**re: Geotechnical Review – Site Servicing Plan**  
Proposed Mix-Use Development  
1131-1151 Teron Road - Ottawa

**file:** PG5283-MEMO.03

Paterson reviewed the following drawings prepared by WSP for the proposed mix-use development to be located at the aforementioned site as part of the geotechnical assessment:

- Project No. 20M-01534-00 – Servicing Plan – Drawing No. C03 Revision 2, dated September 3, 2021.
- Project No. 20M-01534-00 – Proposed 250mm W/M Extension in Teron Road – Drawing No. C03A, dated September 3, 2021.

C03

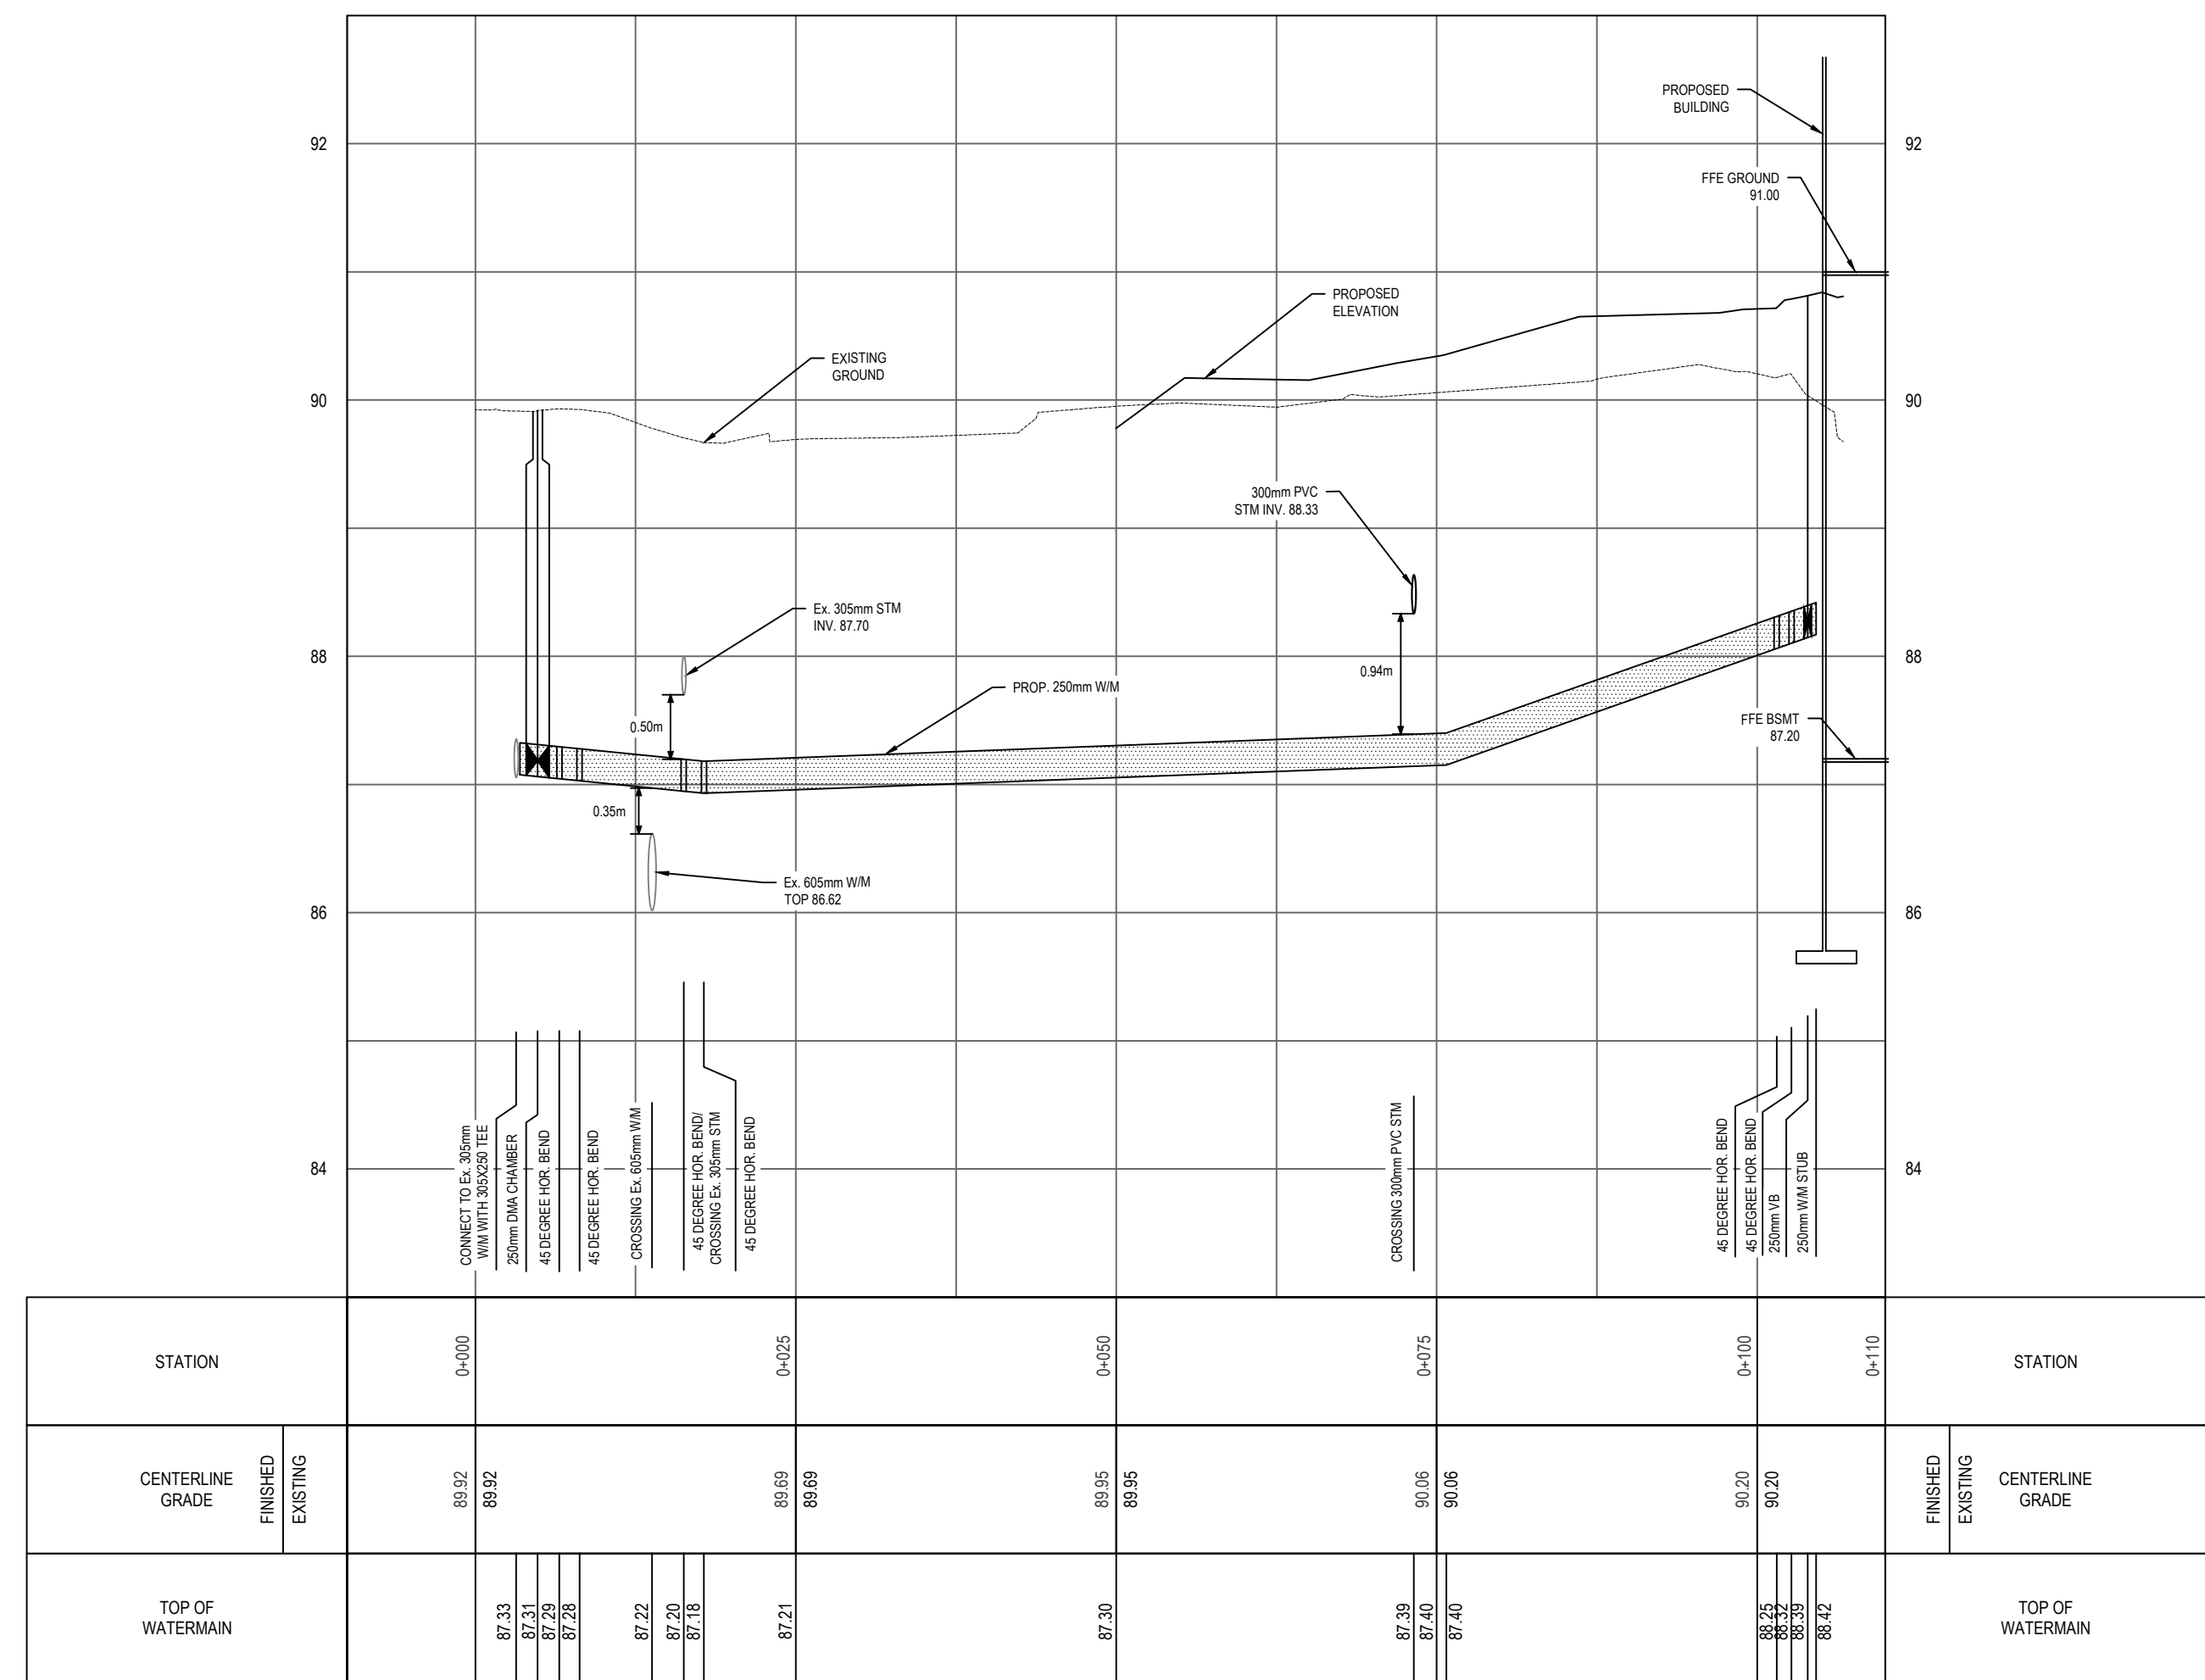
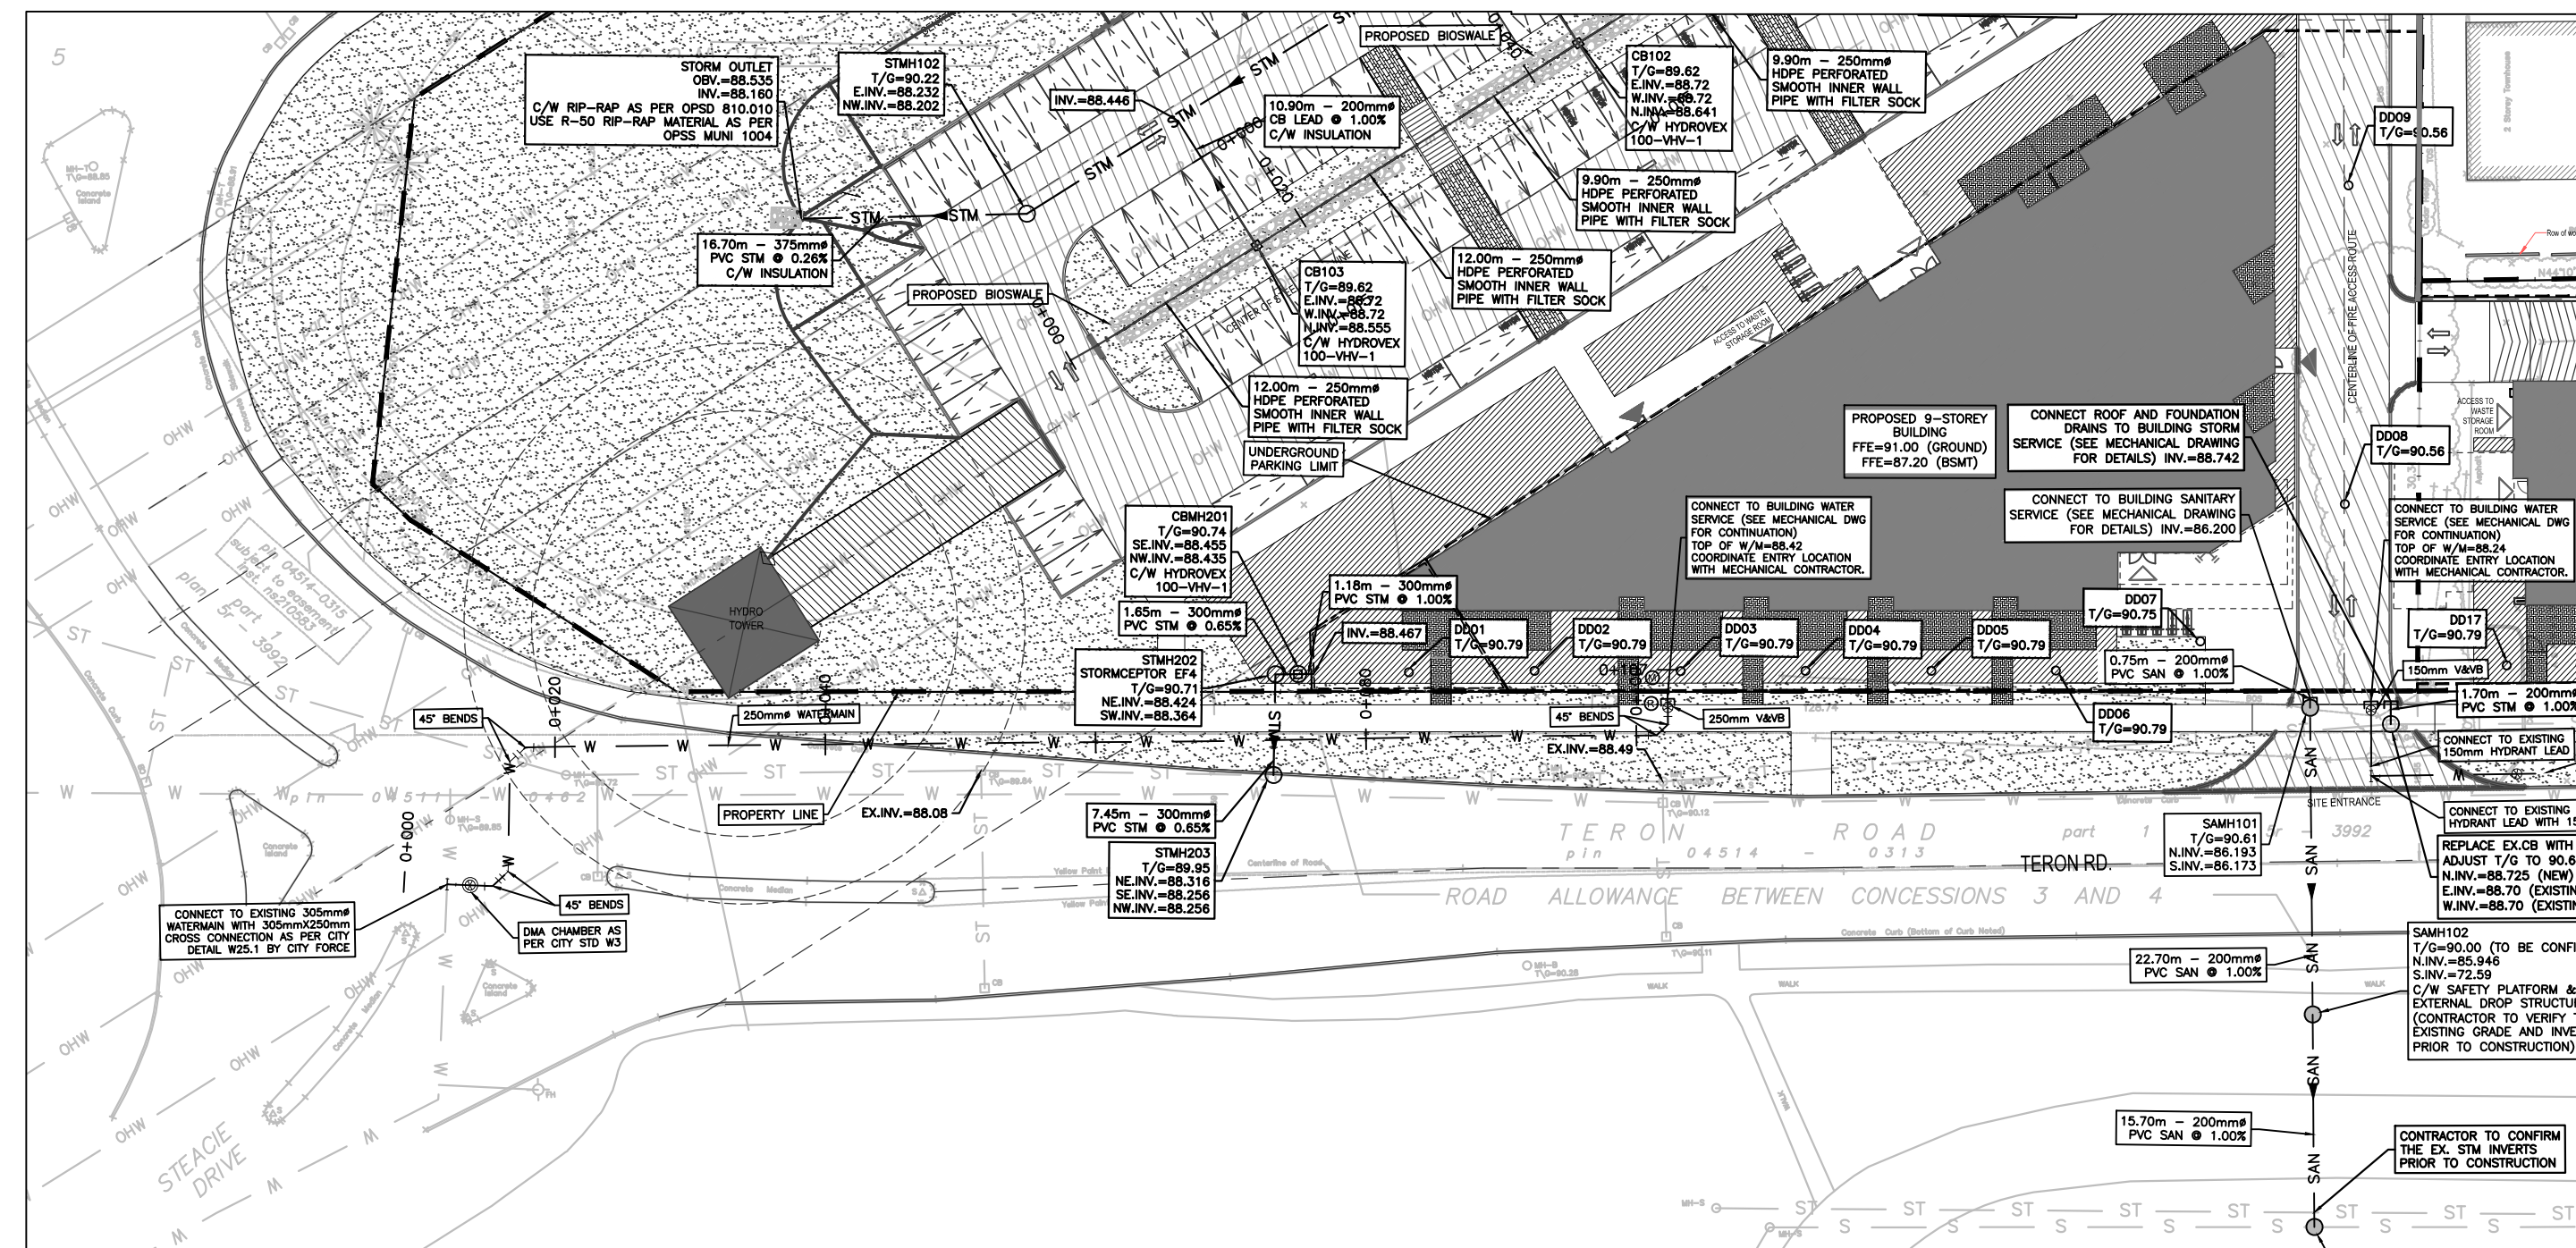
The proposed watermain which runs parallel to the southwestern property boundary is to be connected to the existing 305mm diameter watermain running across the intersection between Teron Road and Steacie Drive. The proposed 250mm watermain was observed to cross below an existing storm pipe which runs from Teron Road towards March road, with a vertical separation of 0.5m. Furthermore, the proposed watermain was also observed to cross below a proposed storm pipe which connects the proposed storm chamber cistern located along the west corner of the 9 storey building to the existing storm pipe along Teron Road. The proposed watermain and proposed storm pipe will have a vertical separation of 0.94m. On the other hand, the proposed 250mm watermain was observed to cross above an existing 605mm watermain with a vertical separation of 0.35m.

The proposed sanitary pipe which runs from the central portion of the south property boundary and runs perpendicular to Teron Road is to be connected to the existing sanitary pipe located along Teron Road at an invert level of 72.44m. The proposed 200mm sanitary pipe was observed to cross below an existing watermain and storm pipes with unknown invert levels running parallel to the near lane of Teron Road and an existing storm pipe with unknown invert level running parallel to the farthest lane of Teron Road.

- The side slopes of the excavation above the invert level of the existing service pipes can be cut back at acceptable slopes. Unsupported excavation side slopes, extending to a maximum depth of 3 m, should be cut back at 1H:1V, or shallower. For excavation below the invert level of the existing service pipes, an engineered trench box approved by a structural engineer is recommended to be in place at all times to support the sides of the excavation. A vertical cut could be completed safely in this manner.

- Extra precautions should be taken during excavation around and below the existing services where the proposed watermain/sanitary pipes will be crossing below the existing storm sewer and watermain. It is suggested that hand digging or using a 'hydrovac' technique be used when excavating in close proximity to the existing storm sewer and watermain to avoid any potential damage to the existing mainline pipes. It is expected that pipe bedding below the proposed service alignments will be in accordance with the recommendations provided in Paterson Report PG5283-1 Revision 1 dated September 20, 2021.

- The excavated area below the existing storm sewer and watermain should be reviewed by the geotechnical consultant and backfilled with an unshrinkable fill (0.3 to 0.5 MPa - compressive strength). The unshrinkable fill should in-fill the excavated area adjacent to the installed watermain/sanitary sewer and extend vertically to the invert level of the existing storm sewer and watermain pipe and horizontally to the supported sides of the excavation. Furthermore, the unshrinkable fill shall extended horizontally beyond the face of the existing service pipes a minimum distance of 300 mm. The unshrinkable fill should be placed against a clean, excavation sidewall face to eliminate any voids that may cause settlement issues.
